Project: **EPPING PARK, 61 MOBBS LANE EPPING**

Report: **BCA ASSESSMENT REPORT ON
BUILDINGS 3, 4, 5 AND 7**

Date: 27th April 2009

01 HOUSE 1 MEZZANINE  
1:200 @ A1

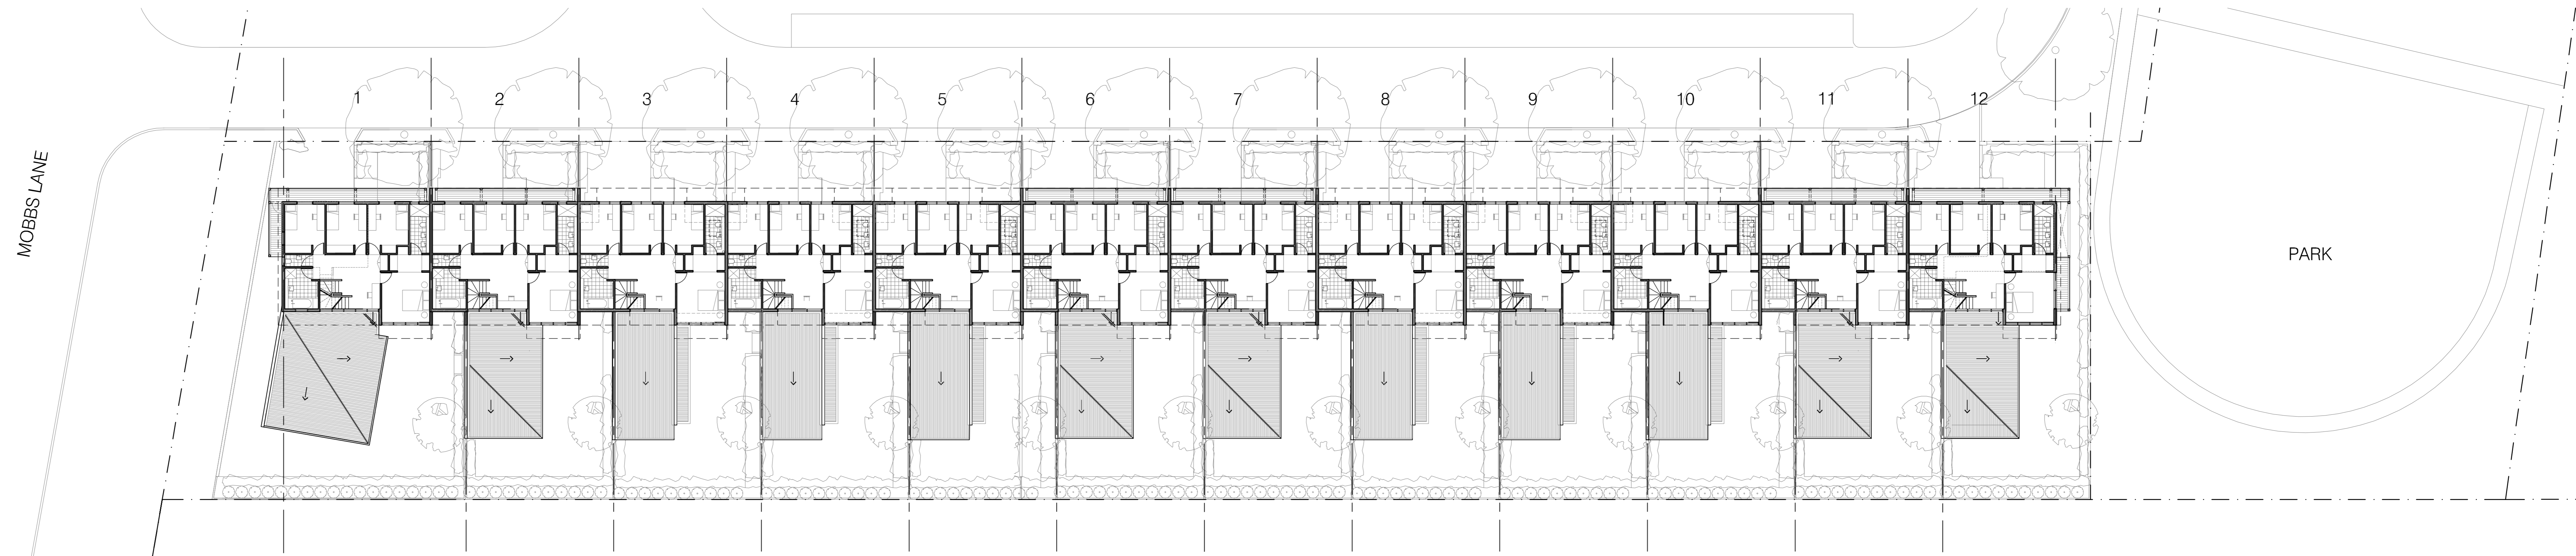
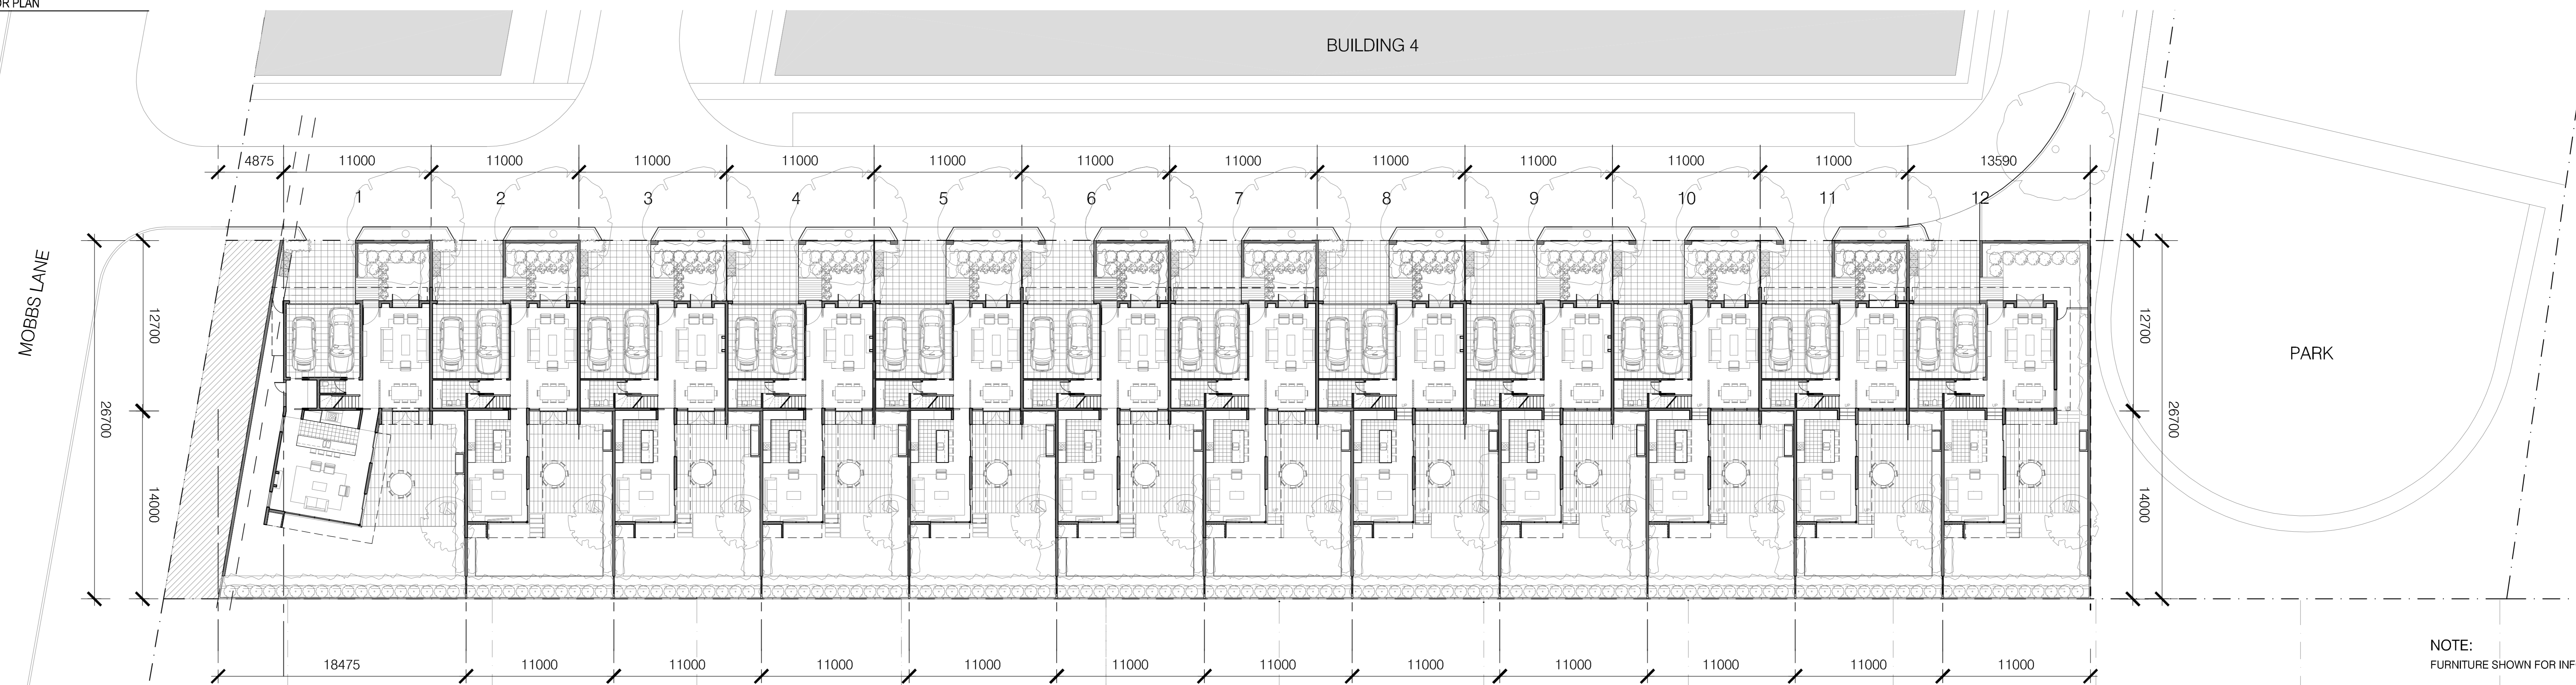
- (a) The walls separating each dwelling will need to be constructed with a 60/60/60 FRL extending fully up to the underside of the roofing material with only timber battens permitted to pass through the fire separating walls in accordance with Part 3.7.1.8 of BCA2009 Volume 2. The construction of the adjoining dwellings must be structurally independent from the adjacent dwelling.

- (b) Details of the proposed individual site boundaries to be provided at the Construction Certificate Stage for further assessment to ensure all windows are located greater than 900mm from any proposed boundaries.

- (c) Any proposed roof lights are to be located greater than 900mm clear of the separating wall in accordance with Part 3.7.1.10 of BCA2009 Volume 2.
- (d) Drainage, gutters and downpipes to comply with AS/NZS 3500.3.2.

Building 4 Basement Carpark

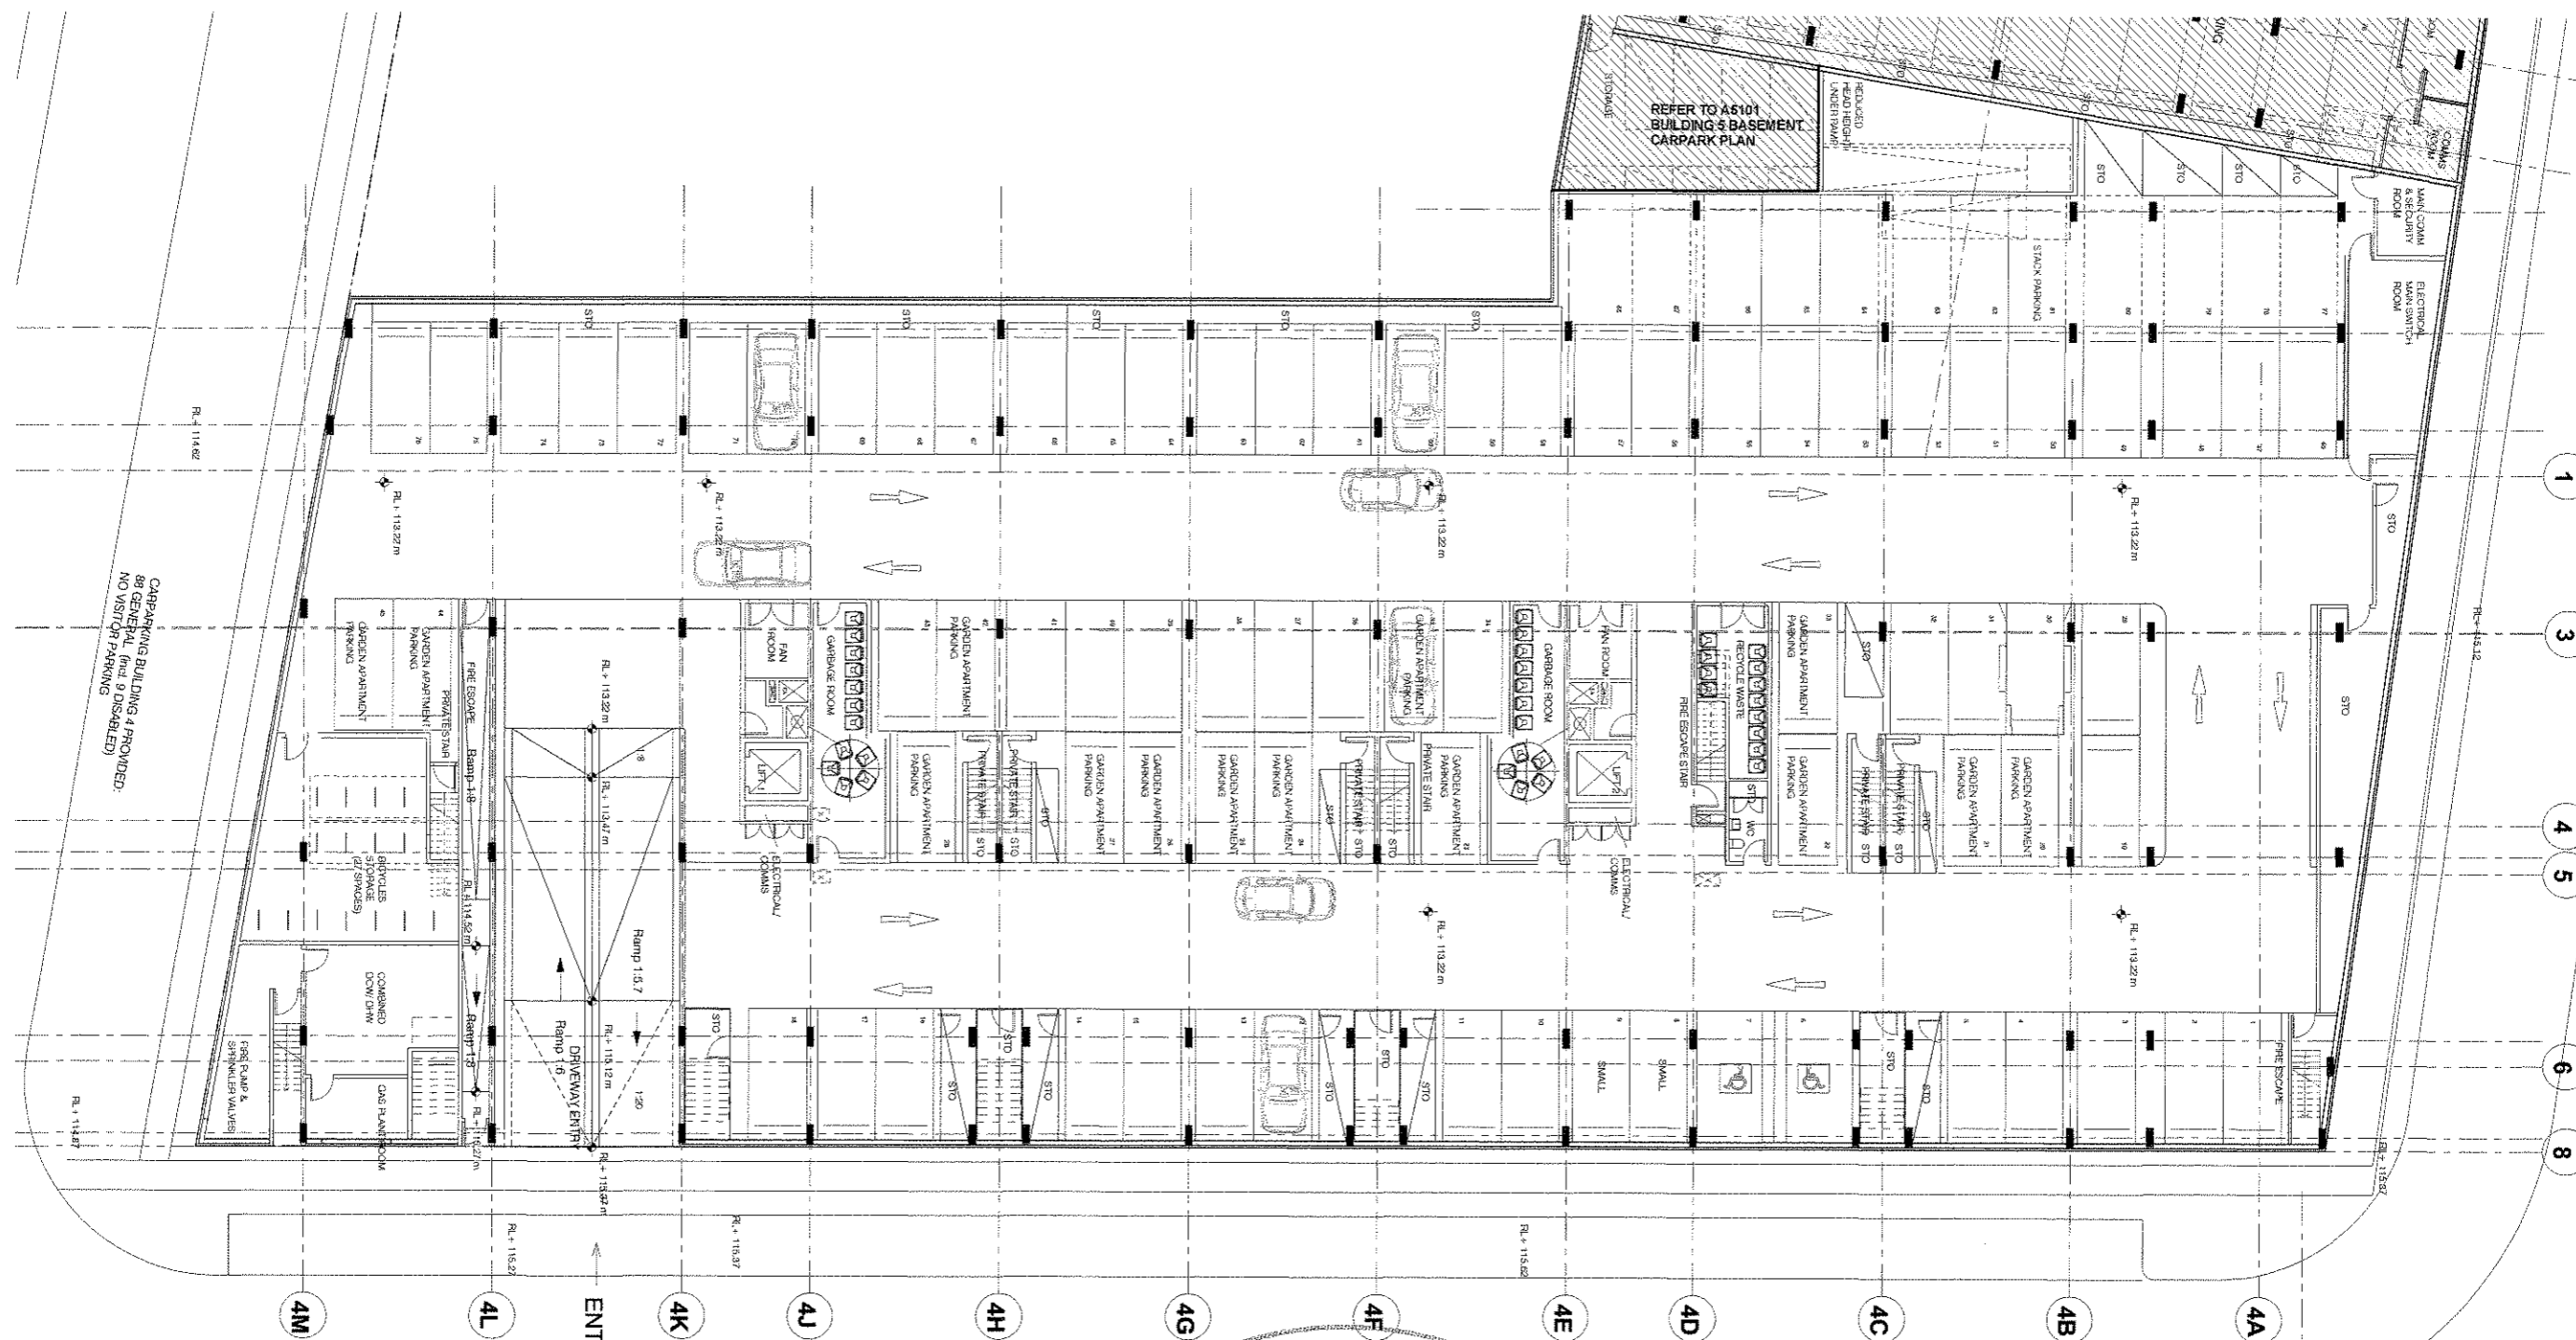
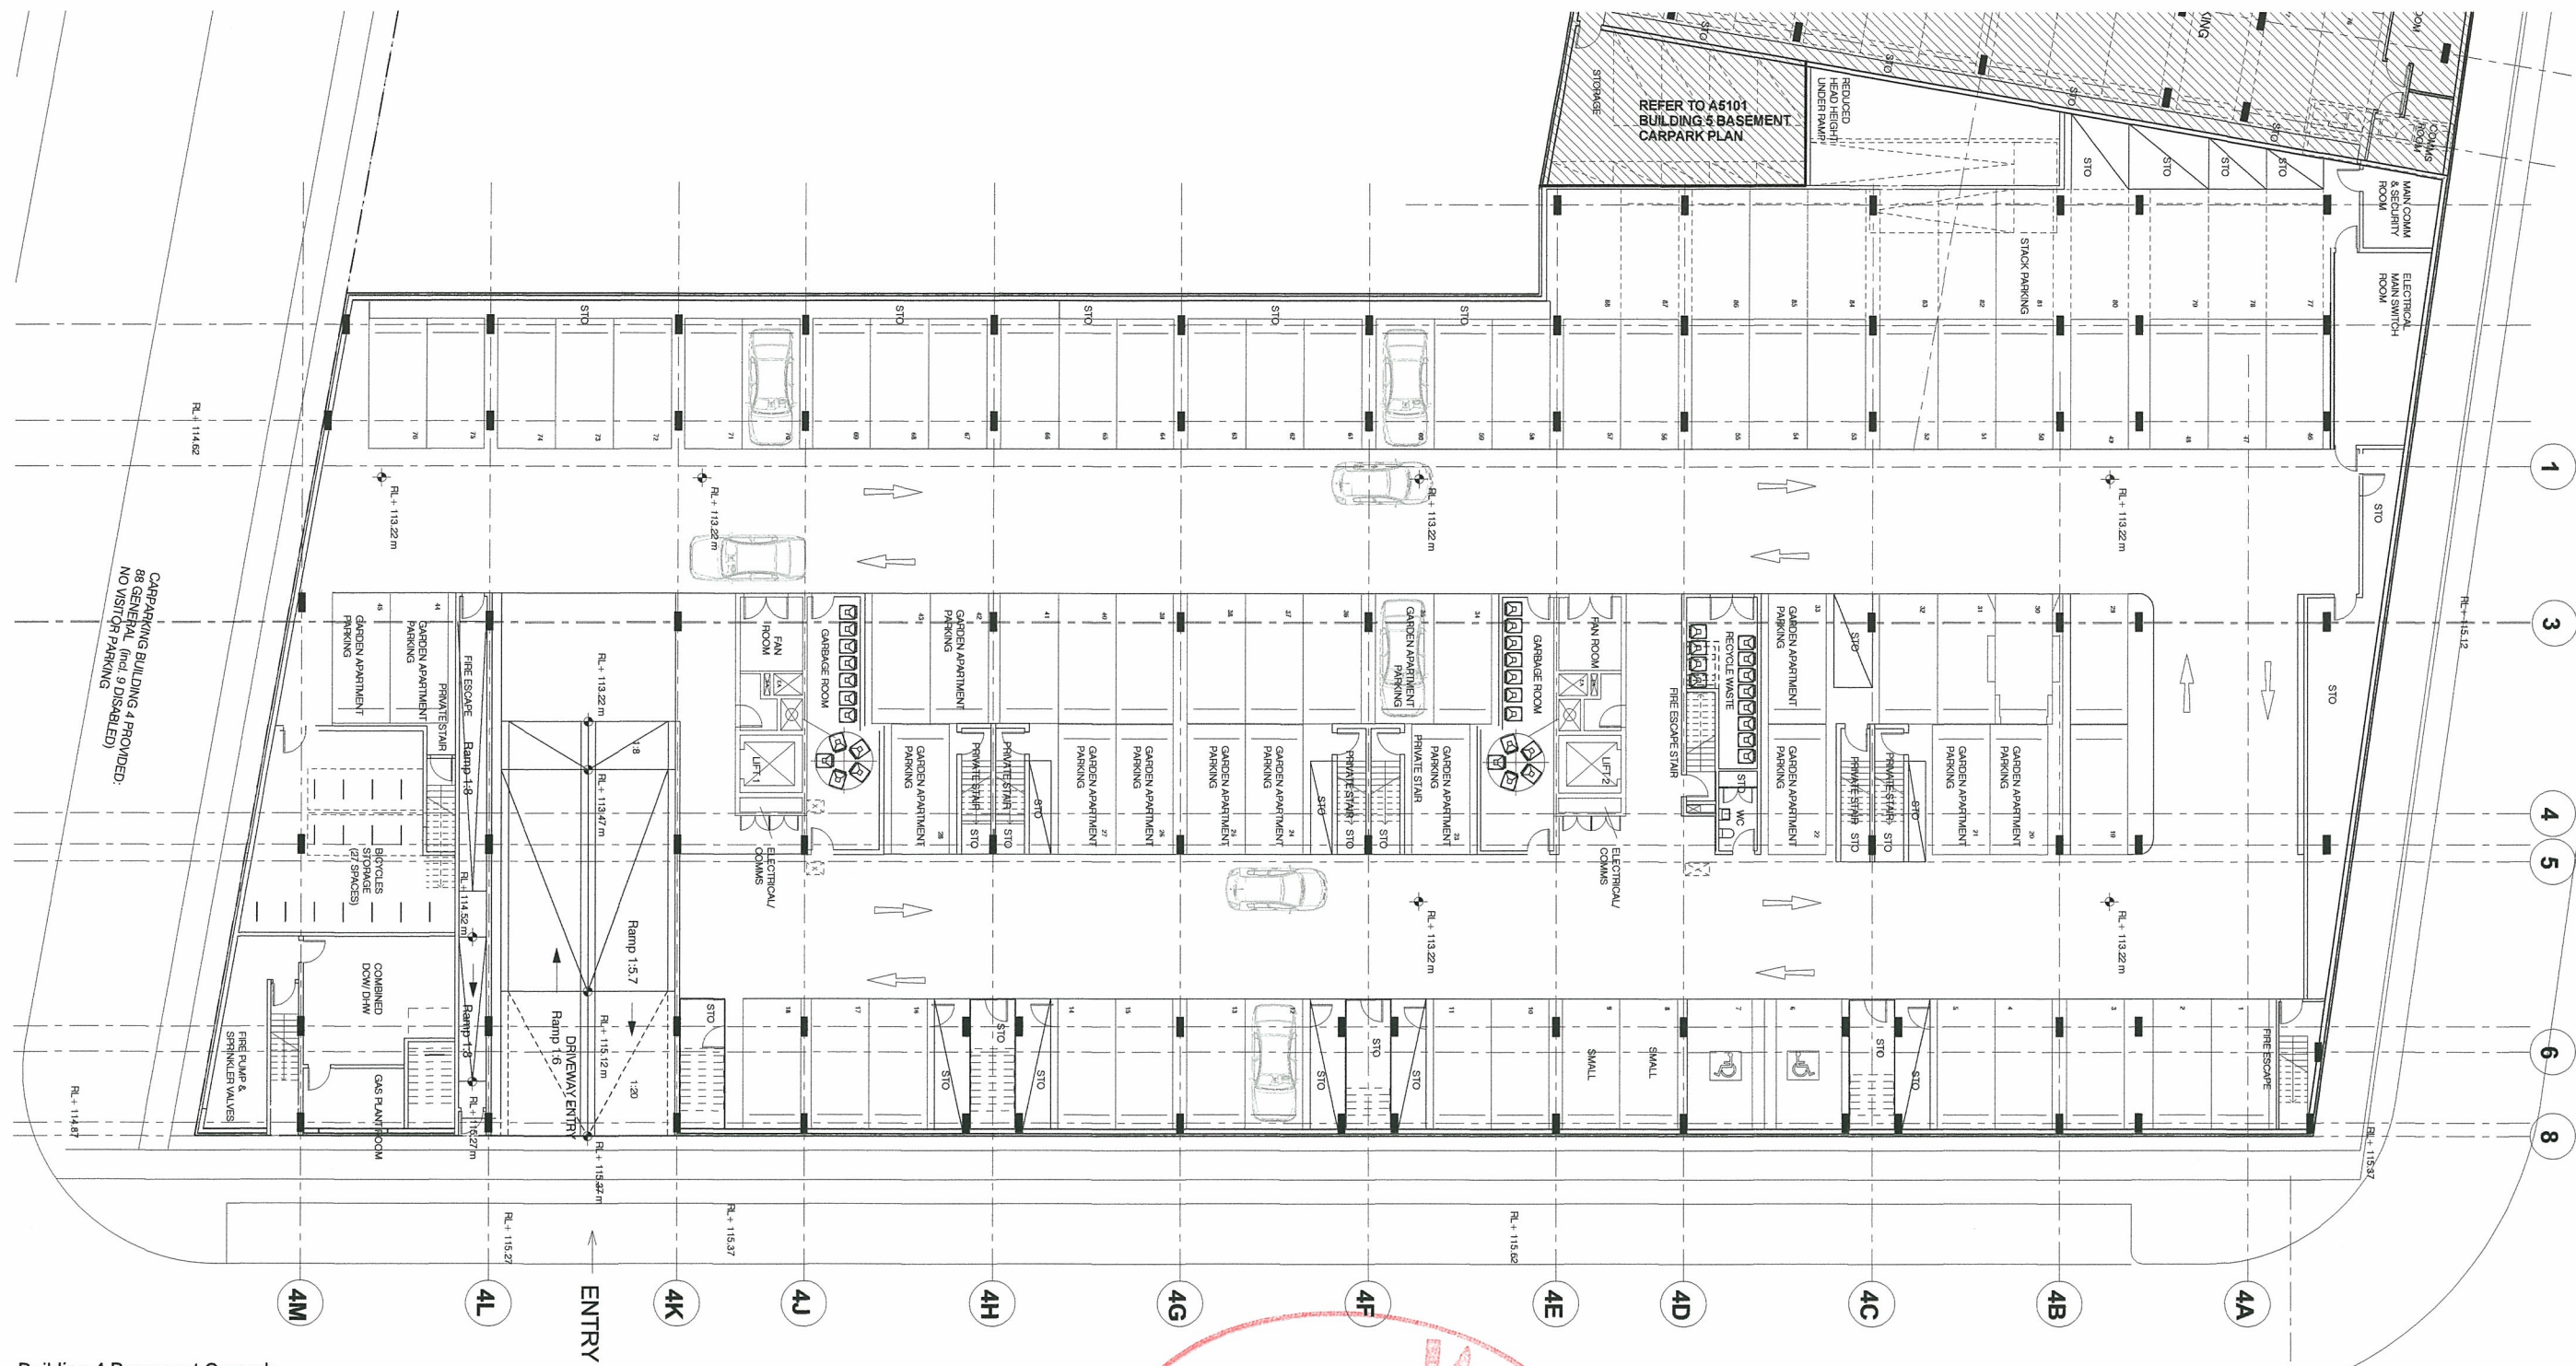
Notes: There are FRL concessions applicable for fully sprinkler protected car park portions under Clause 3.9 of Specification C1.1 of the BCA reducing the car park FRL's down from 120/120/120 to 60/60/60. As a portion of the roof deck of the basement level car park to Buildings 4 / 5 is required to be used as true "open space" for the purposes of egress this portion of the car park and supporting structure must have an FRL of 120/120/120 as required by D2.12.
